# Rezoning Transportation Analysis

Petition Number: 2021-174

Date	Description
11-22-21	First Review (TM)

**OVERALL**

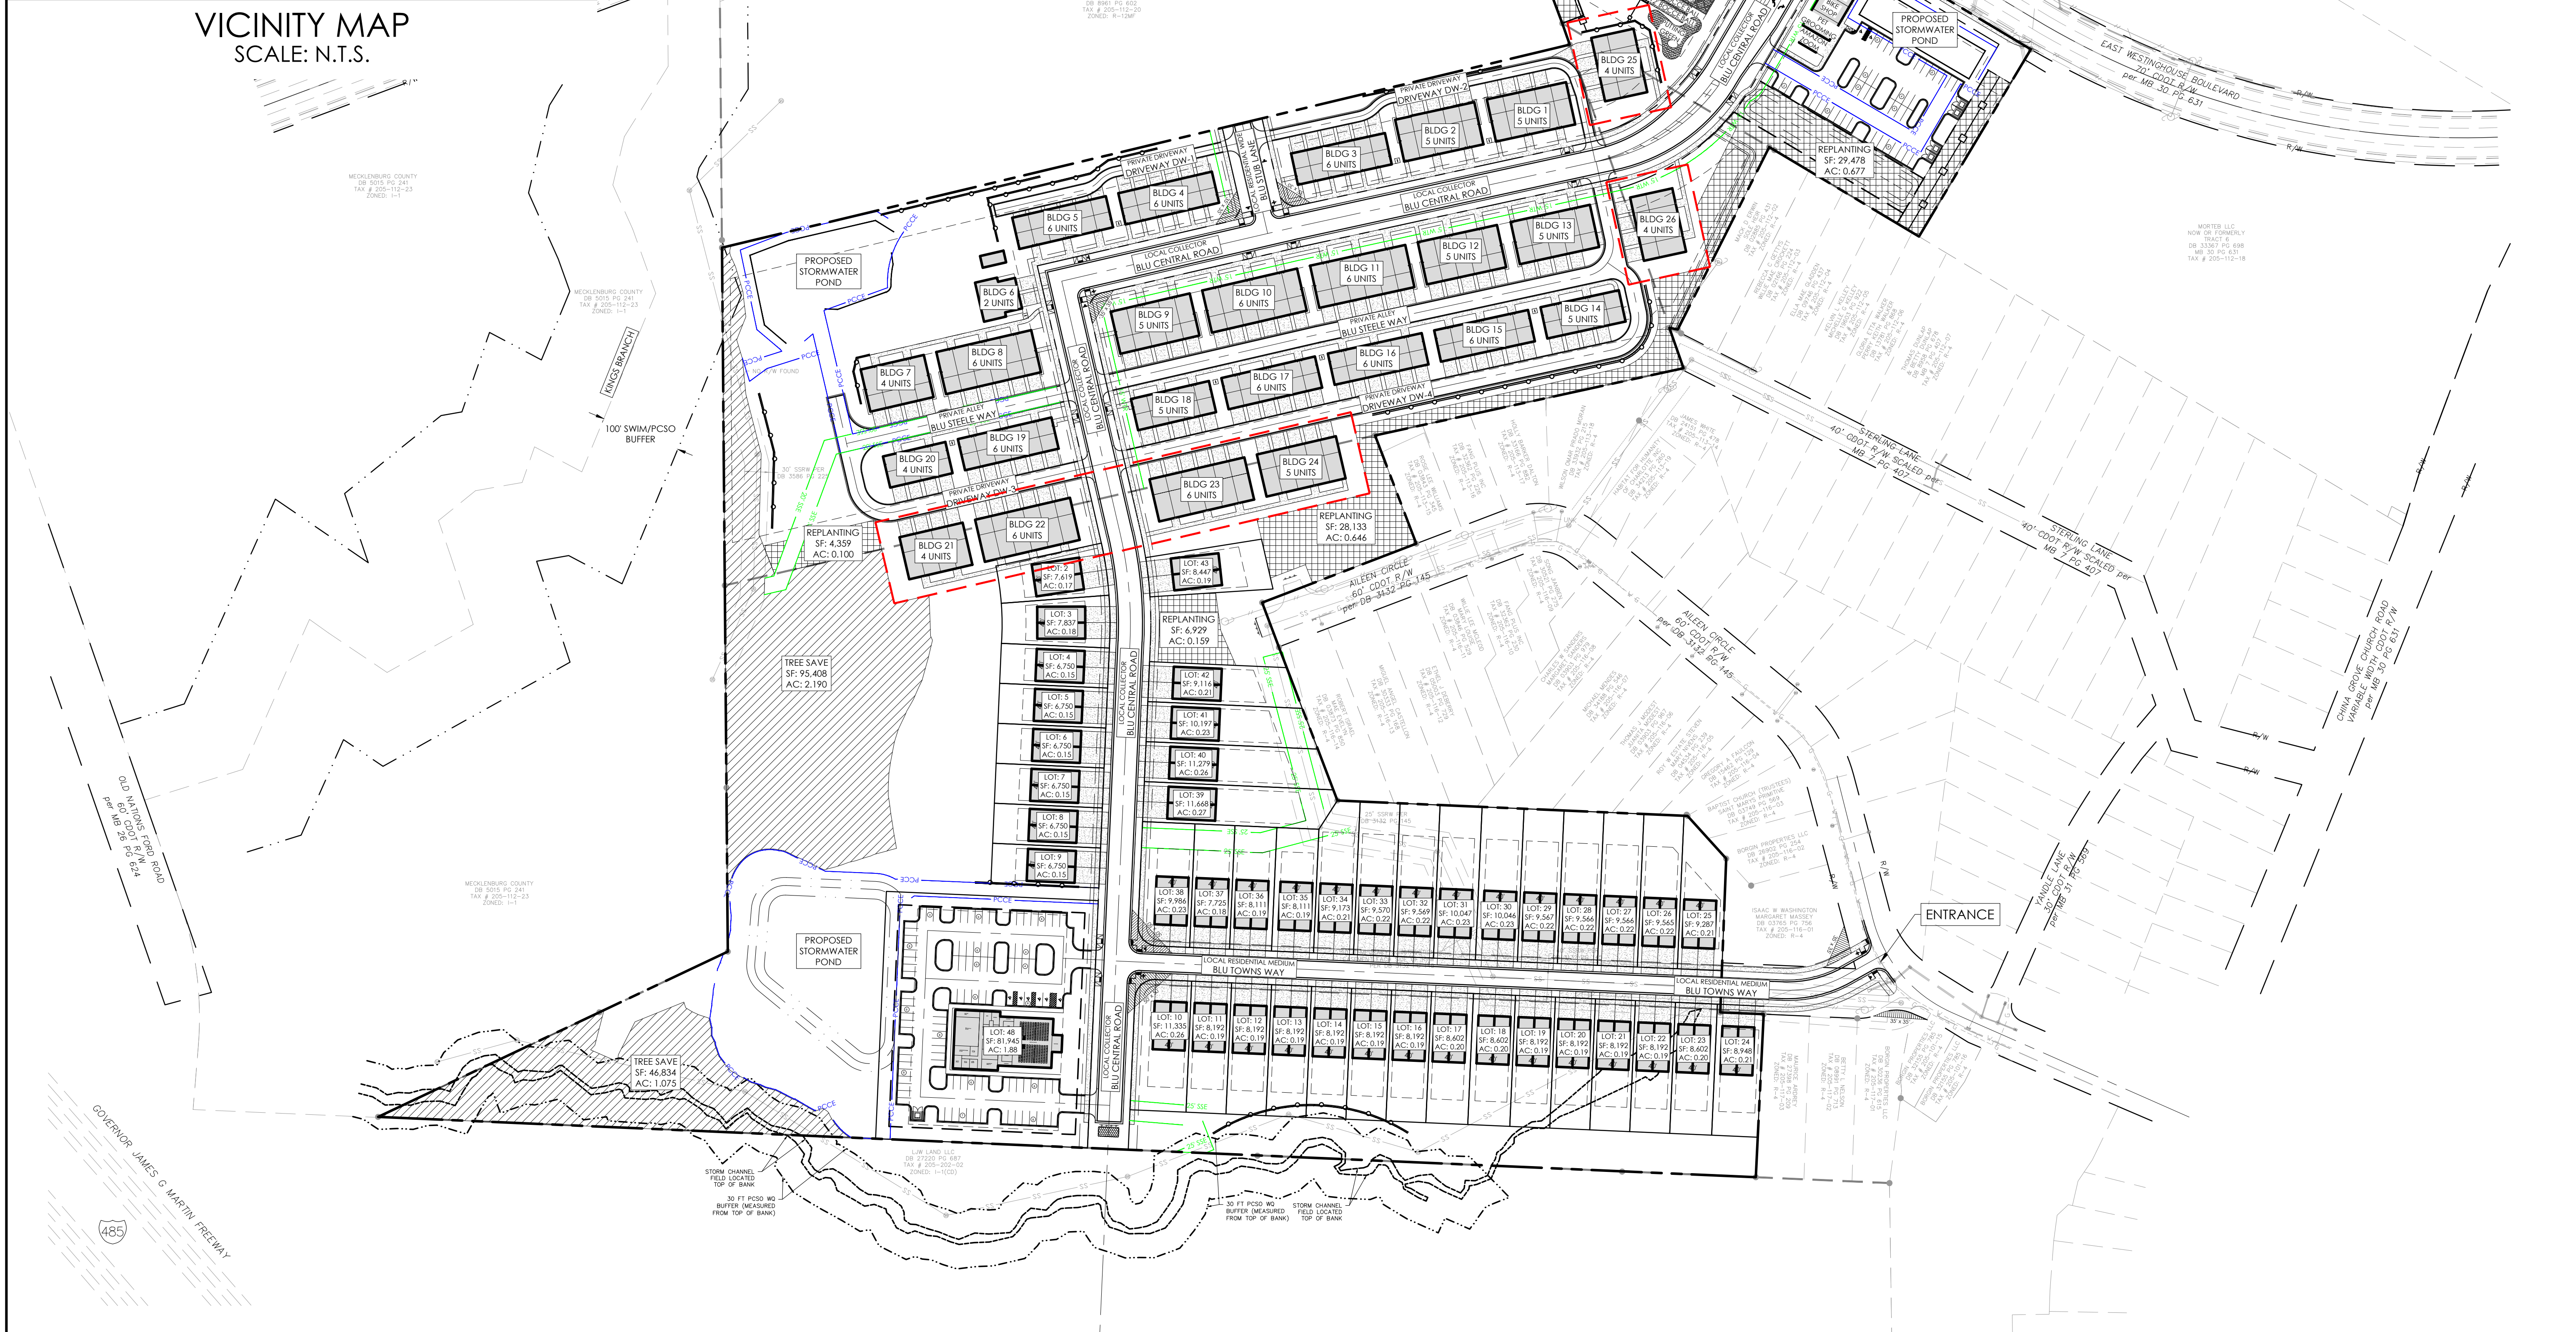
- Curblines:** The proposed zoning district has a setback measured from back of the existing or proposed future curblines.
  - East Westinghouse Boulevard:** Location of the future back of curb and gutter will be relocated is 33 feet from the existing street centerline. Revise site plan to show the future back of curb.

Label and dimension the existing and future curb and gutter from the centerline for each road on the site plan.

3. Revise site plan and conditional note(s) to commit to dedicate 50' right-of-way from the road centerline. The site plan shall label and dimension the right-of-way from the road centerline on East Westinghouse Boulevard.
4. Revise site plan to extend Aileen Circle to Blu Central Road as a Local Residential Medium street per CLDSM U-02.

5. The proposed dwelling units exceeds 12 per acre. Per Chapter 20 Subdivision ordinance, site plan and conditional note(s) revisions are needed to commit to construct an 8-foot planting strip, and 12-foot multi-use path along East Westinghouse Boulevard. The planting strip and multi-use path will be measured from the future back of curb. The wider multi-use path also meets the Charlotte WALKS Policy and Charlotte BIKE Policy.
